Planning Application Ref: BN/51/20/PL

Location: Land at Chantry Mead & rear of 14-18 Downview Road, Barnham, PO22 0EG

Description of works: 4No. dwellings including access, landscaping & associated works

Drawing No **LLD1880-ARB-DWG-002** Revision **00**

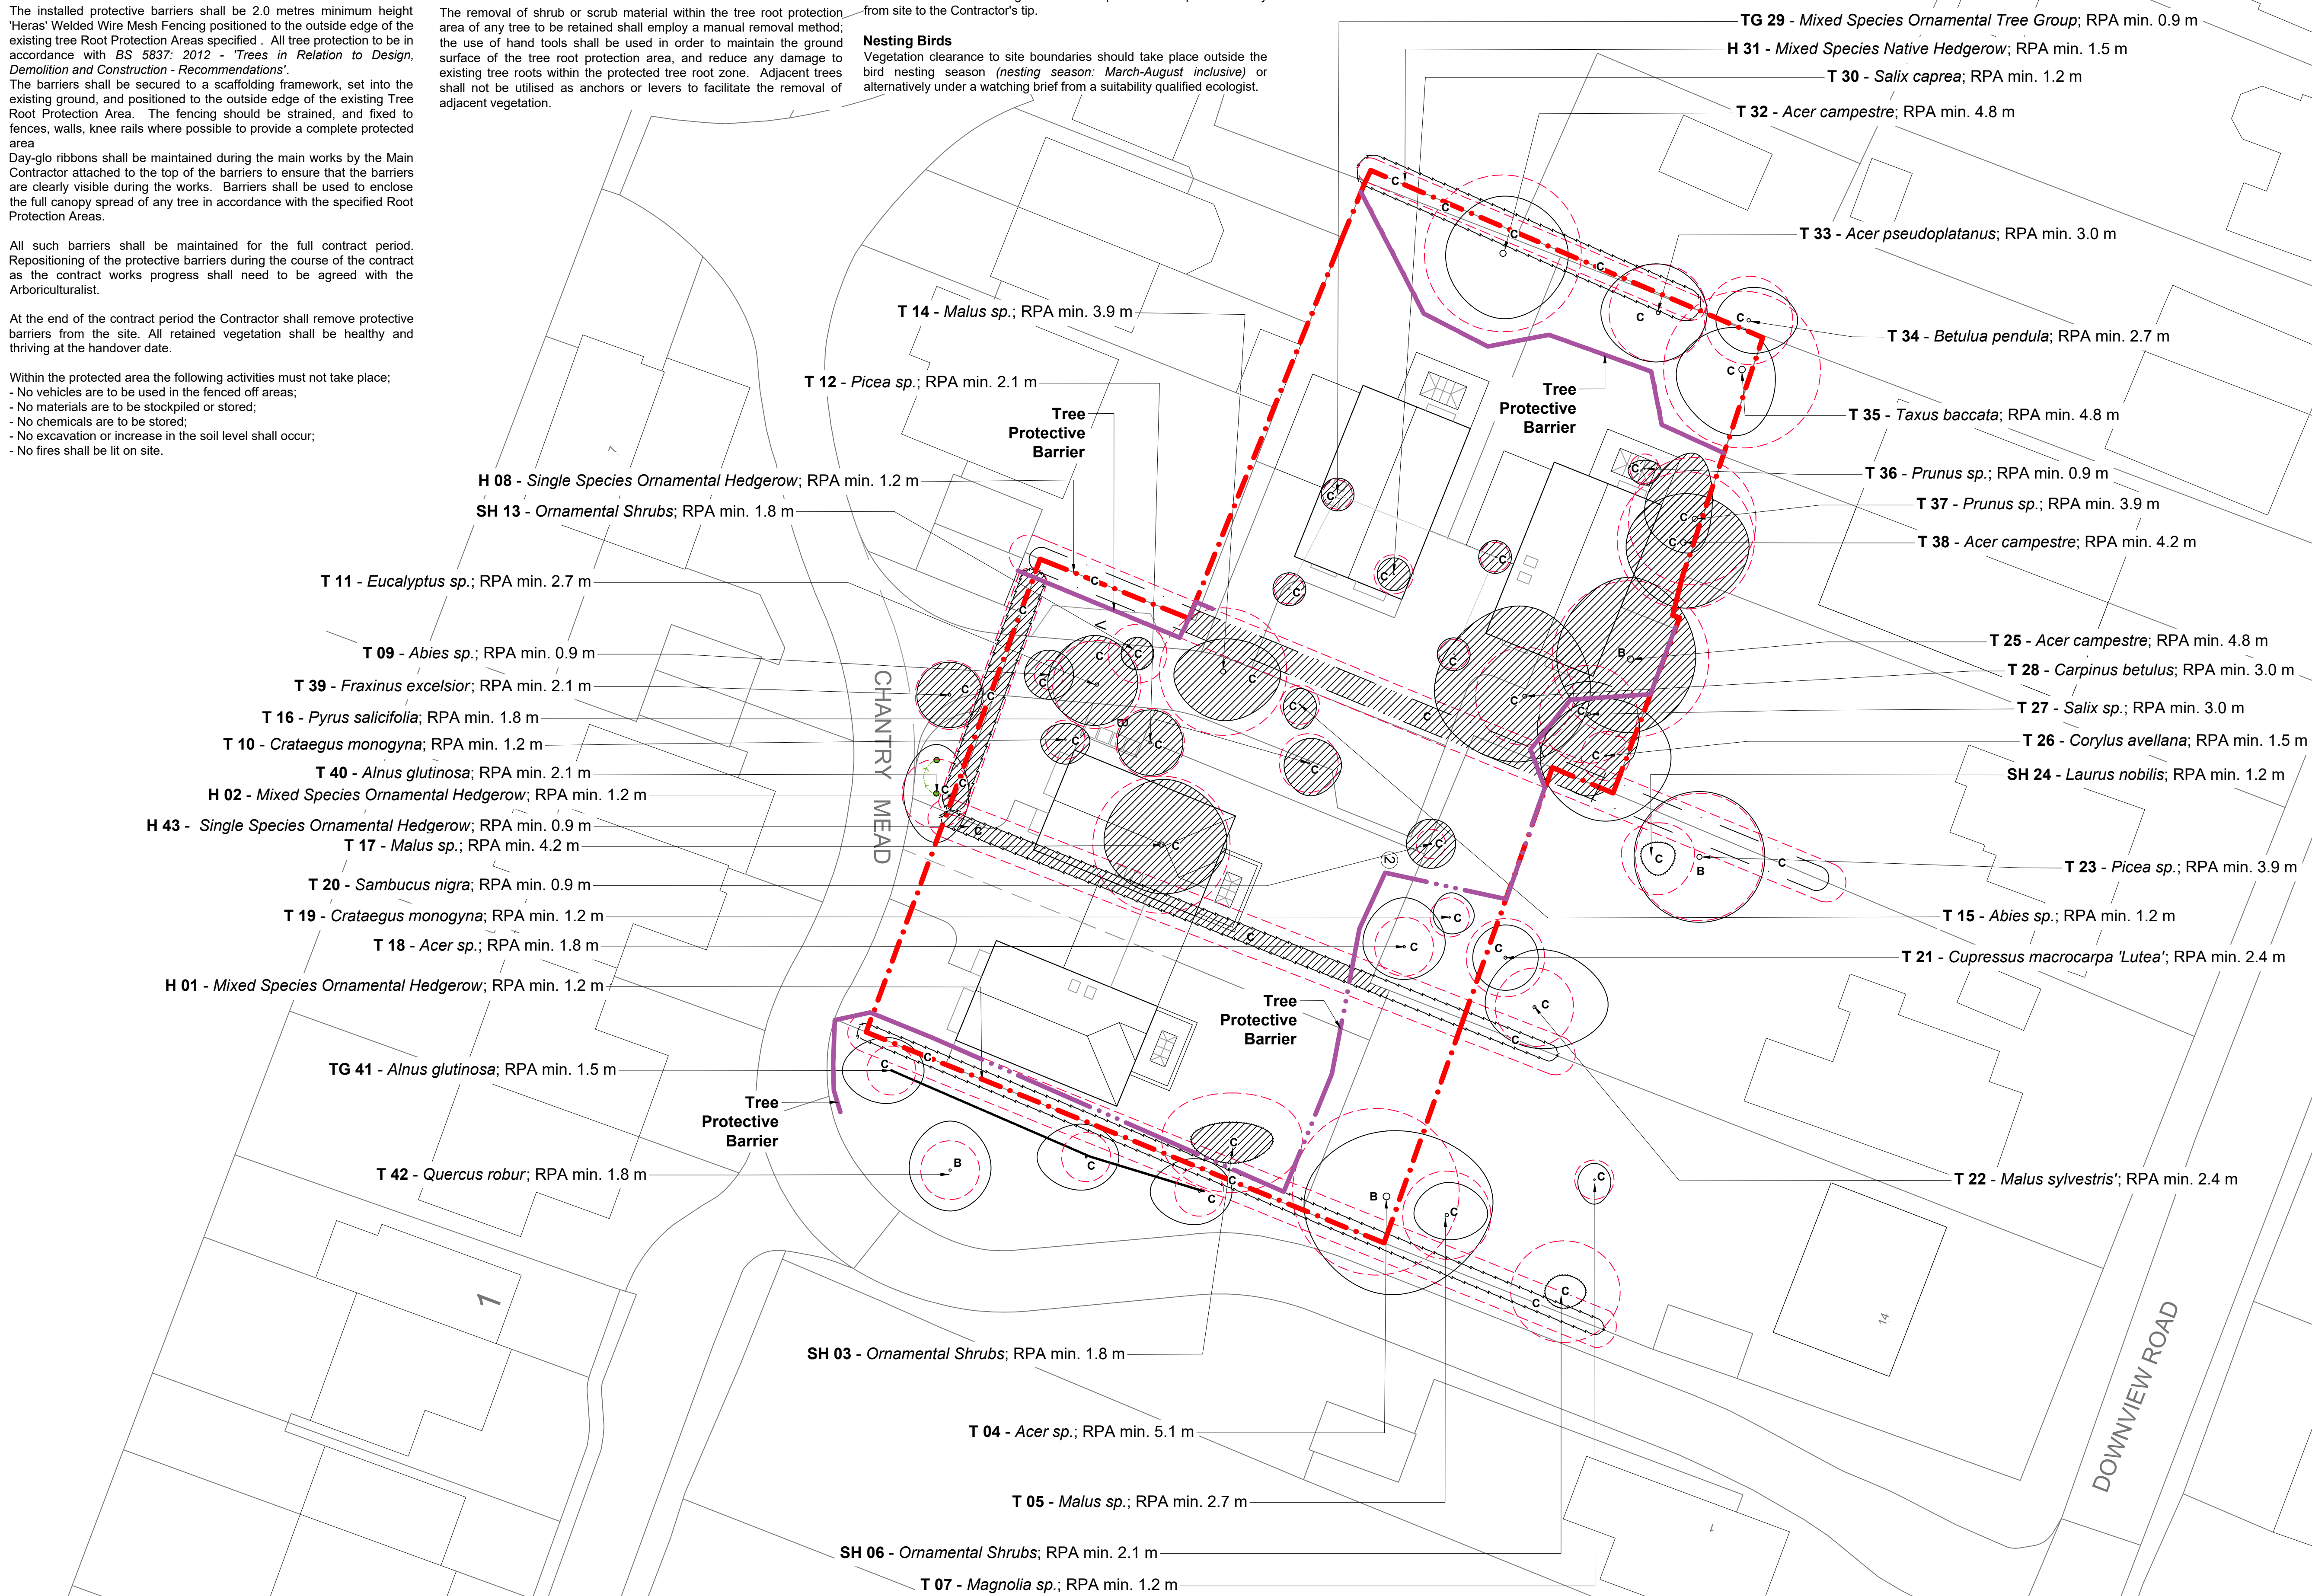
- As it stands, I see no reason to object to these proposals on arboricultural grounds. If you are minded to approve this application, I recommend the following conditions be applied:
1. Before the site is occupied or any machinery is introduced to the site or demolition work or construction work or alterations to existing ground levels takes place a **PRE-COMMENCEMENT Site Meeting** is to take place between the Planning Authority's Tree Officer and the Arboricultural Expert representing the site owner(s) – at this meeting all protective fencing and ground protection measures will be inspected to verify they are 'Fit for Purpose' as required under British Standard 5837:2012 and have been erected and positioned exactly as shown on the **Tree Retention and Protection Plan, LLD1880-ARB-DWG-002, Rev 00**.
